Ribble Valley Borough Council
Council Offices
Church Walk,
Clitheroe
Lancashire
BB7 2RA

Your ref: 3/2024/0778

Date: 14 April 2025

Location: Bramley Farm Cottages Clerk Hill Road Sabden BB7 9FQ
Proposal: Regularisation of change of use of barn (Shippon House) from holiday accommodation to permanent residential dwelling and erection of single-storey extension.
Grid Ref: 375458 436800

Proposed Site Plan
scale 1:1200
0 1 5 10m

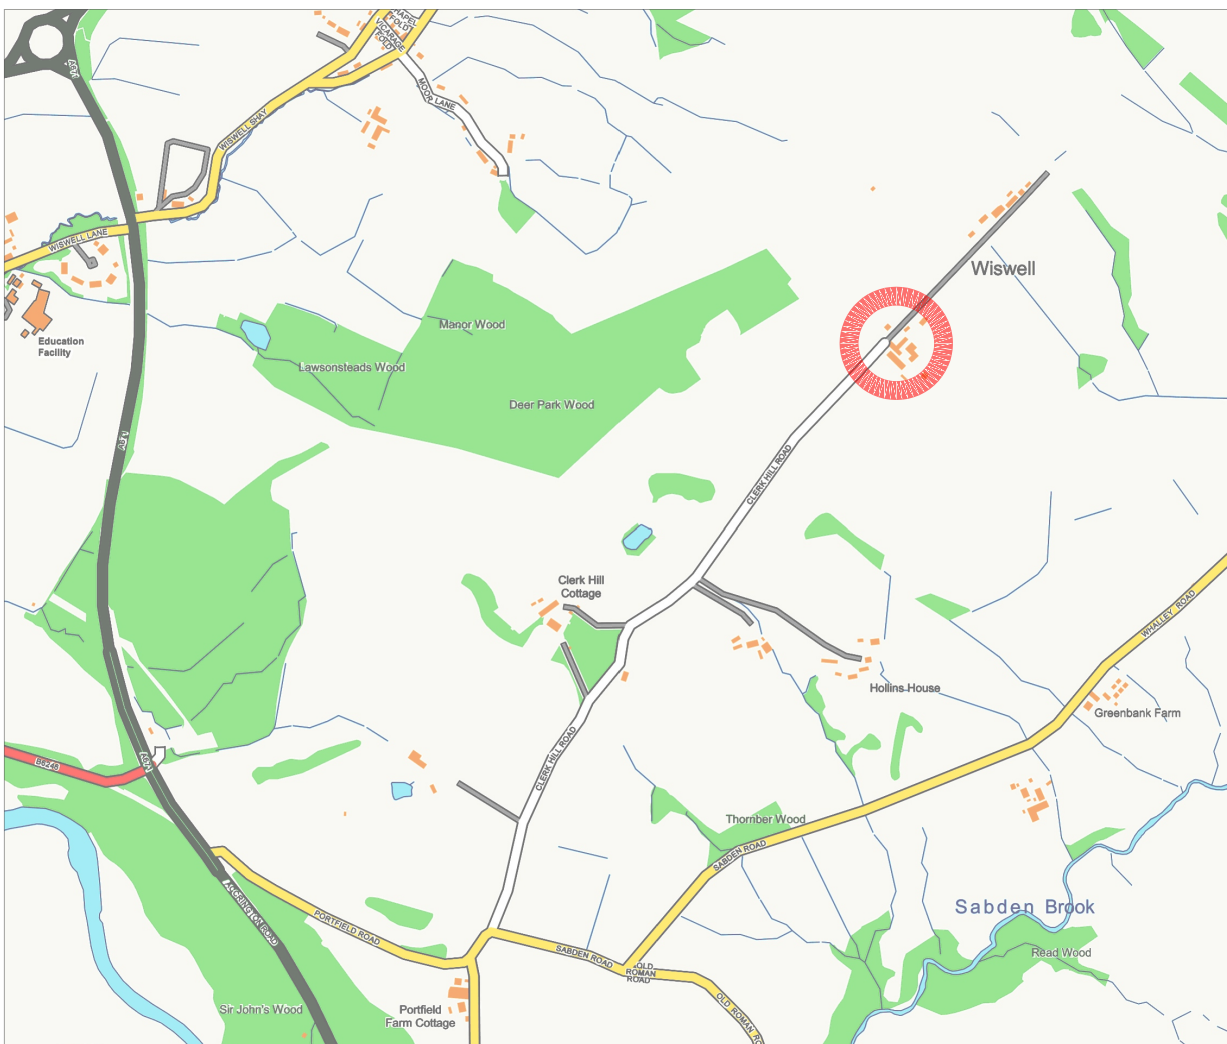
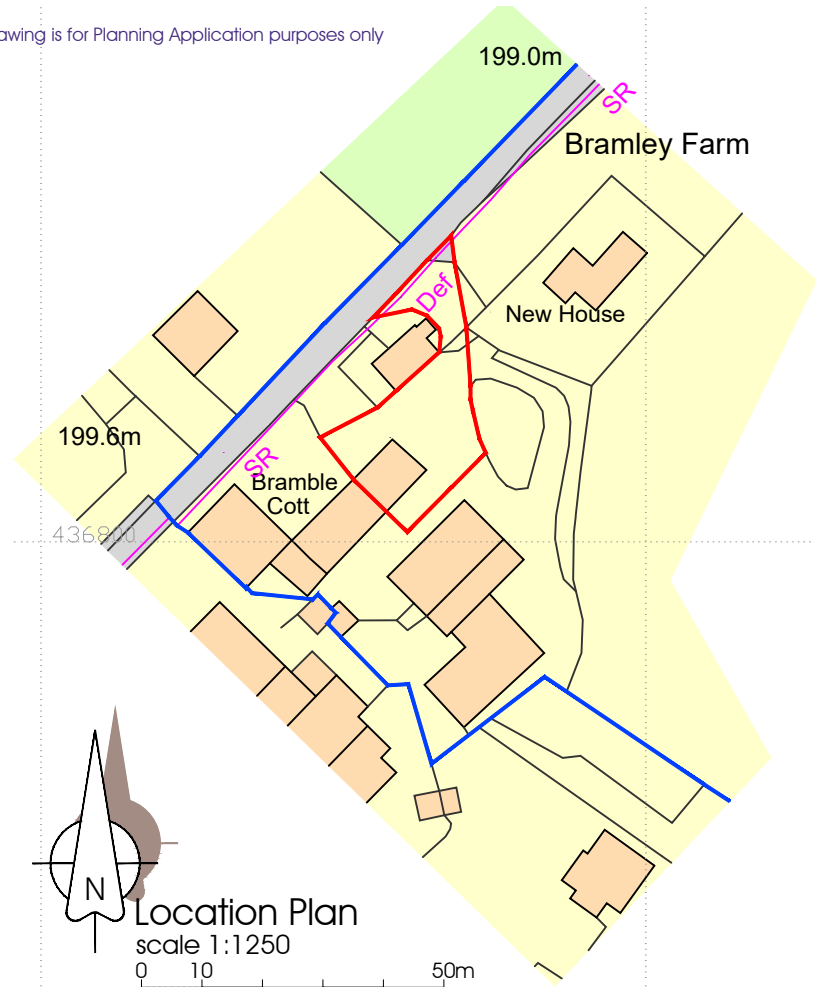
The LHA have reviewed the Site Plan and are aware that the dwelling complies with the LHAs parking standards as defined in the Joint Lancashire Structure Plan. Therefore, the LHA have no objection to the proposal. There is also room to turn enabling ingress and egress in a forward gear.

The site would benefit from increasing its sustainable transport options to encourage and promote sustainable transport use. Therefore, the LHA recommend that the development include covered secure cycle to ensure the provision and availability of adequate cycle parking for each resident and the promotion of sustainable forms of transport. Additionally, due to the nature of the application, it is expected that a charging point for electric vehicles is included in the development to promote sustainable modes of transport. The DfT guidance regarding Electric Vehicle Charging in Residential and Non-residential buildings states charge points must have a minimum power rating output of 7kW and be fitted with a universal socket that can charge all types of electric vehicles.

1. The car parking and turning areas shall thereafter be kept available for the parking and manoeuvring of vehicles at all times.
Reason: To ensure the provision of adequate car parking on site and in the interests of highway safety.
2. Within 3 months of this permission cycle storage provisions for the residential unit shall be submitted to the Local Planning Authority, in consultation with the Local Highway Authority. These cycle facilities shall thereafter be kept free of obstruction and available for the parking of bicycles only at all times.
Reason: To promote sustainable transport as a travel option, encourage healthy communities and reduce carbon emissions.
